From: Robert Findlay
Sent: 01 December 2011 12:46
To: Planning.Responses
Subject: RE: Planning Consultation on: BR/267/11/

APPLICATION **BR/267/11/**
NO:

Registered: 18-NOV-11
Site 158 Hawthorn Road Bognor Regis PO21 2EY
Address:

Grid Reference: 492680 99701
Category: Plan Applicat'n
Description of Works: Change of use to reinstate ground floor office to a 1 bed flat

Title:
158 Hawthorn Road
Bognor Regis PO21 2EY
Details:
Existing and Proposed Layout
Scale: 1:50
Drawn by: VK
Date: 16 th November 2011

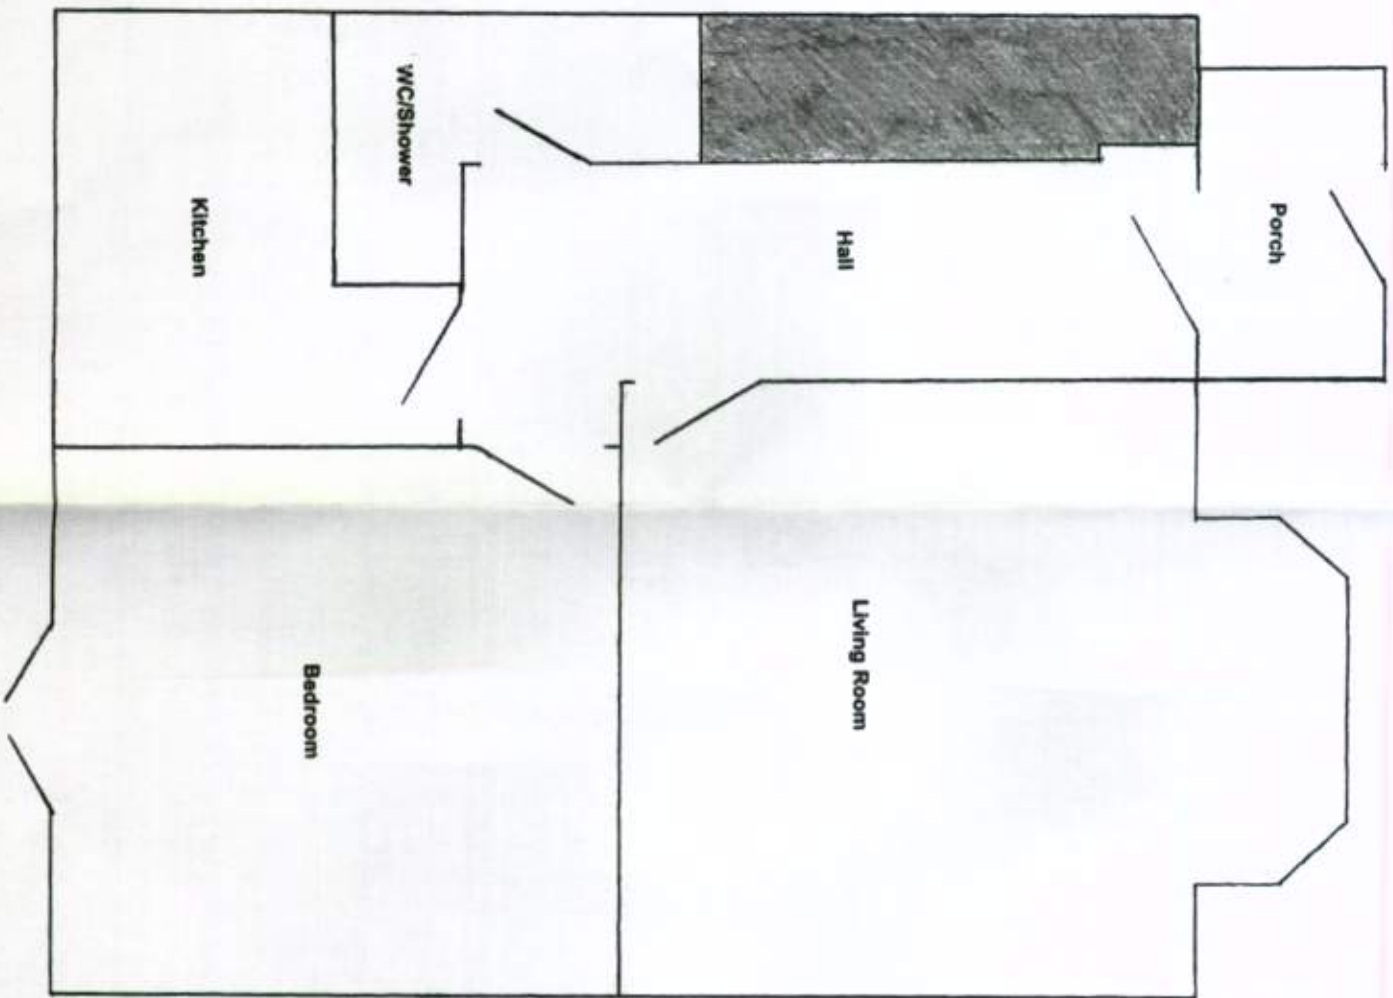
There are no objections in principle however the accompanying letter states the submitted drawings are at a scale of 1:50 yet the scale drawn indicates a scale of possibly 1:500 I presume this is in error. The drawings also do not indicate the position within the proposal of the staircase to the upper storey therefore it is difficult to give a definitive response regarding access and egress throughout this proposal.
